RE: BALDWIN STORAGE BUILDING PHASE 1 (C-18/D18)
(5800 Carmel NE)
ENGINEERS CERTIFICATION FOR CERTIFICATE OF OCCUPANCY
ENGINEERS STAMP DATED 2/20/2002
ENGINEERS CERTIFICATION DATED 8/26/2002

**RE: BALDWIN STORAGE BLDG. PHASE 1 (C-18/D18)
ENGINEERS CERTIFICATION FOR CERTIFICATE OF OCCUPANCY
ENGINEERS STAMP DATED 2/20/2002
ENGINEERS CERTIFICATION DATED 7/25/2002**

Re: Baldwin Storage Building (Holly Avenue NE) Grading & Drainage Plan, Engineer's stamp dated 12-18-01 (C18/D18)

Re: TCL Submittal for Building Permit Approval for
Baldwin Storage Building, [C18 / D18]
6001 Holly Avenue N.E.
Architect's Stamp Dated 12/12/01

SHEET 1 OF 1

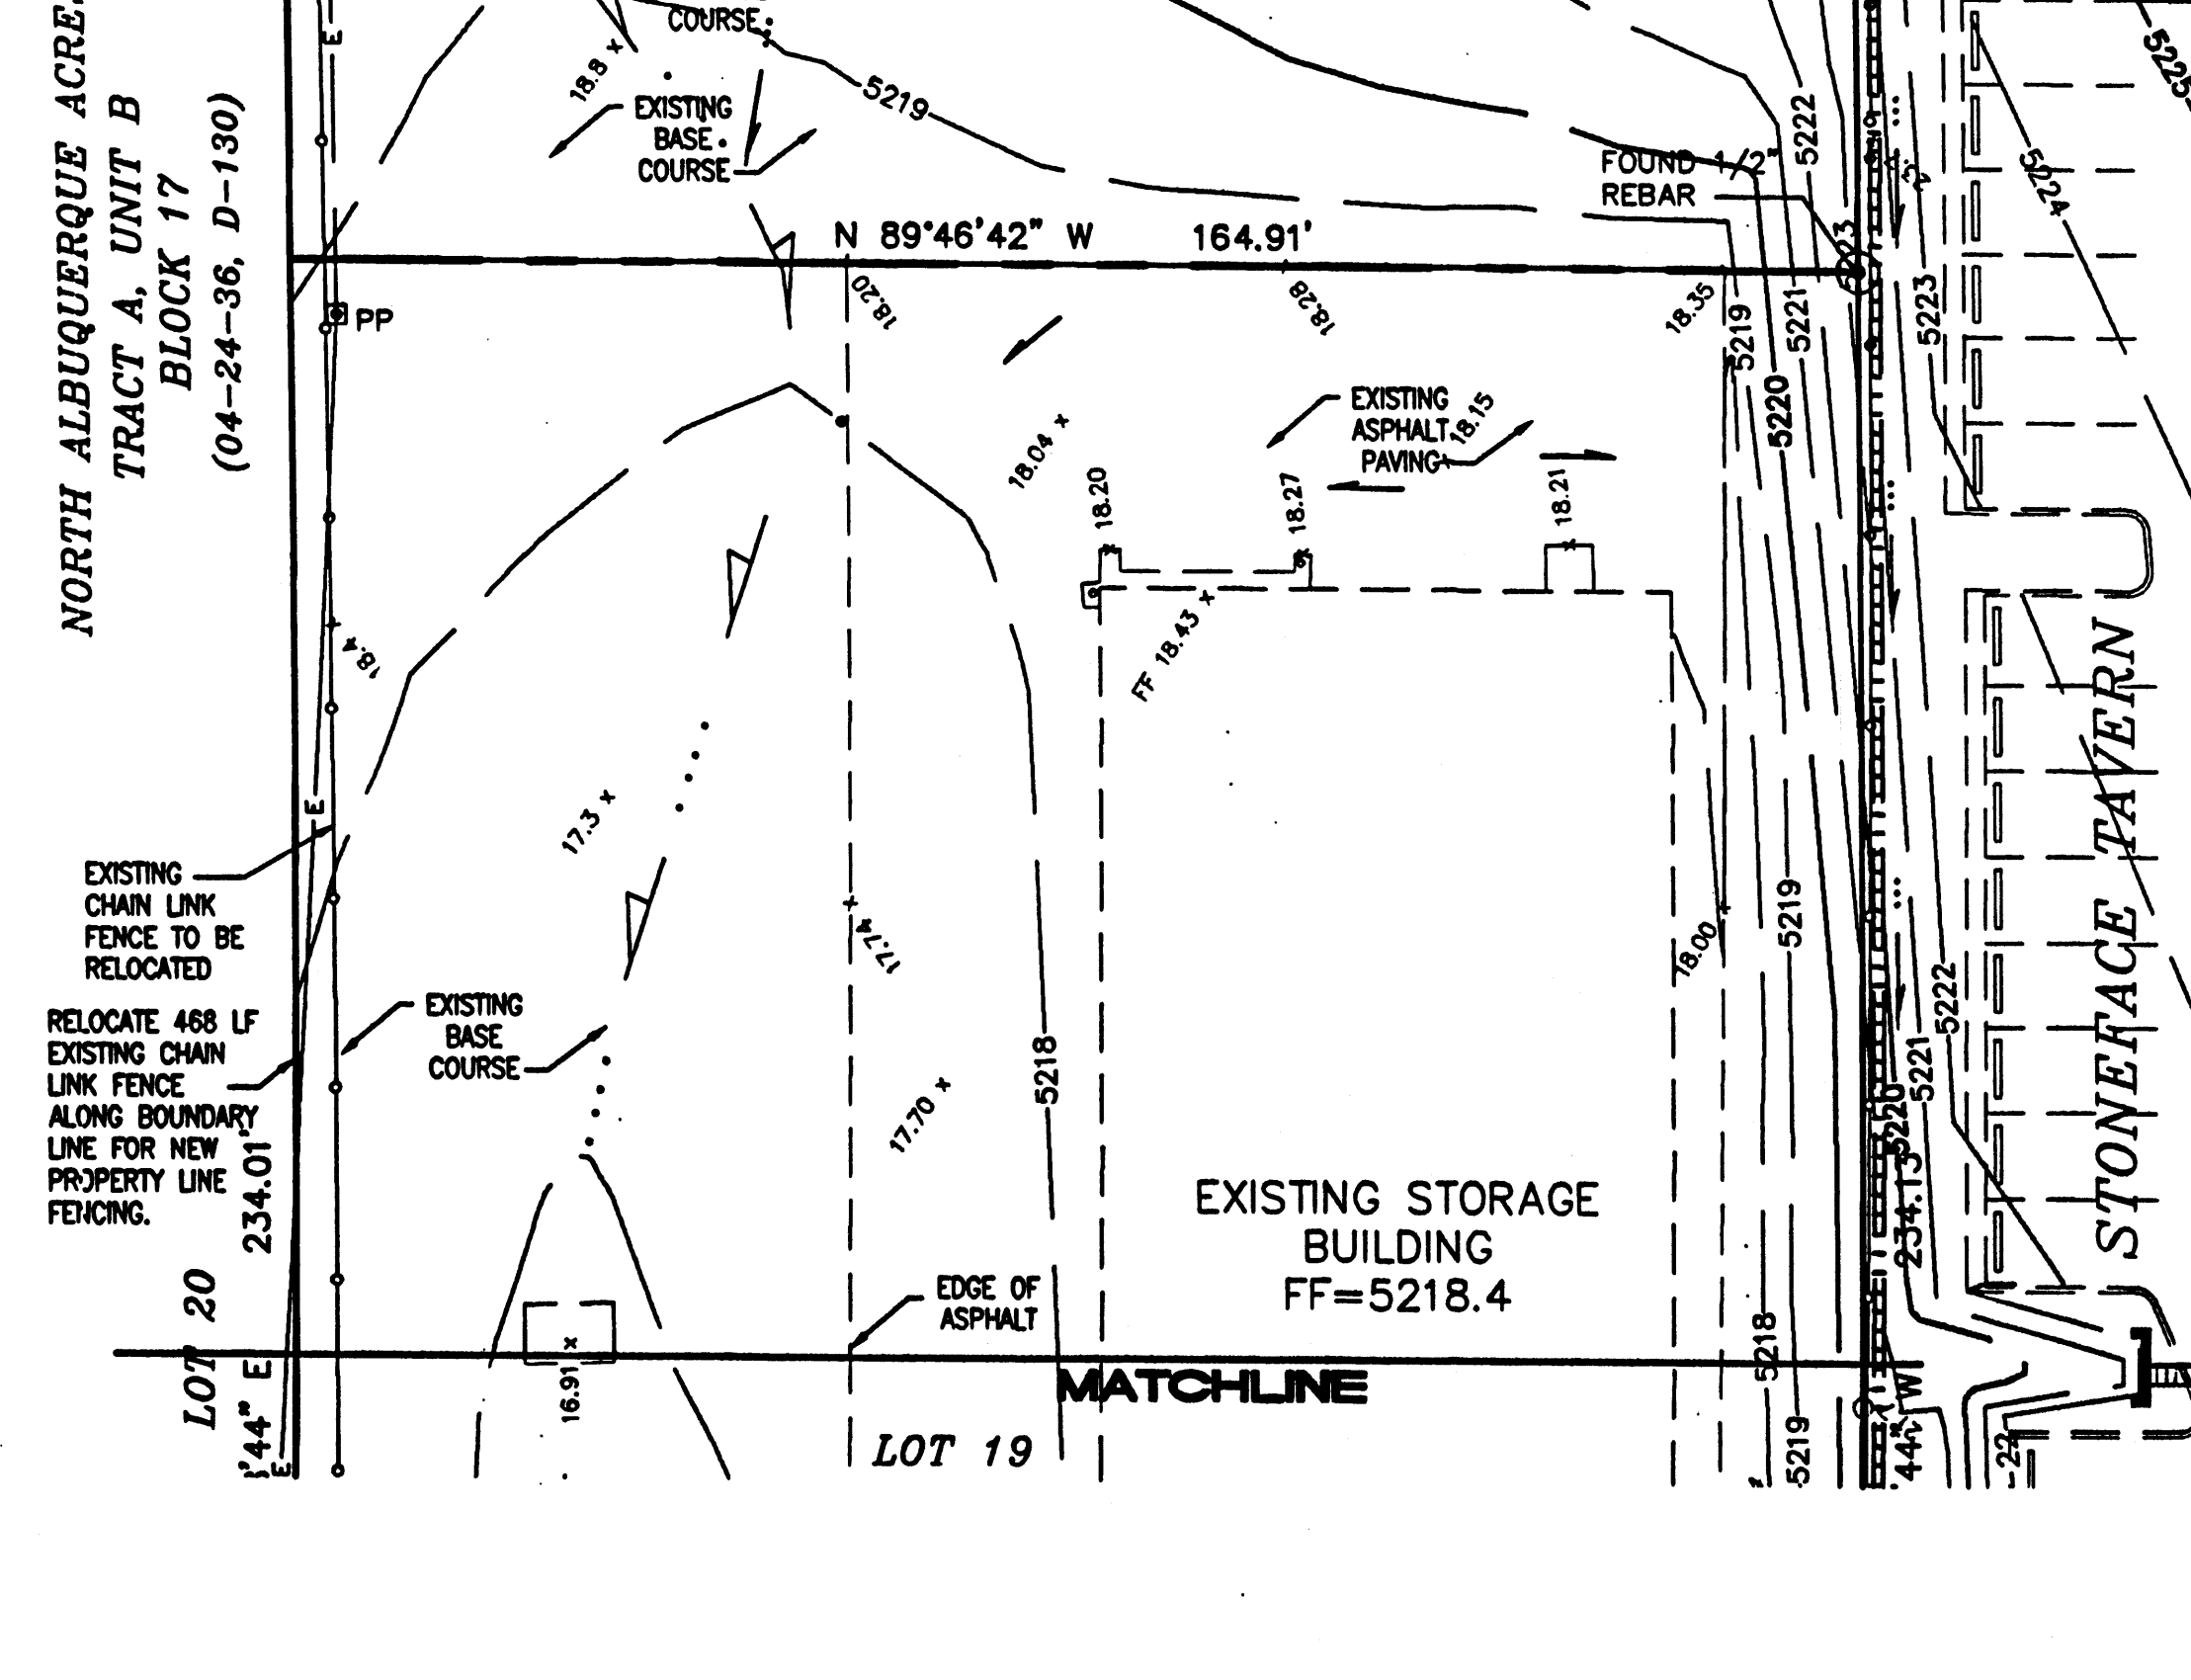
1. There is cross-lot drainage from Lot 14 to the north, which is under the same ownership as the subject property. As I understand it, we allow the cross drainage in this case because Carmel Avenue is too high for Lot 14 to discharge to it. The runoff from Lot 14 will discharge to the rear of the proposed storage building. Your flow arrows show the offsite runoff diverted in an offsite path around the building. Please explain how this happens since there is no barrier to accomplish the diversion.

3. You state that allowable discharge is limited to 2.6 cfs per acre to Holly Avenue. What is the 100-year runoff rate from your site?
4. Is there a reason why the onsite improved detention pond has no emergency spillway? It is going to receive most of the Lot 14 undeveloped discharge, and about half of the onsite Lot 19 developed discharge. This amounts to well over 6000 cubic feet in the 100-year event. If the storage is 3150 cubic feet with a 4-inch diameter outlet pipe, the pond will overflow. Put an emergency spillway on the south side of the pond; suggest armoring it with large cobbles.

5. You show a different hatch symbol at the proposed refuse container location. I assume it is concrete; please identify. Also, the curb does not look right at the refuse location; I think you need the curb along the back, not the front.

6. You list the area as 1.7727 acres. Please add a note that this includes Lot 14 and Lot 19.
7. Typos: The first sentence after the Existing Conditions heading makes no sense. Also, please change "excess participation" to "excess precipitation" in the paragraph after your land treatment table.
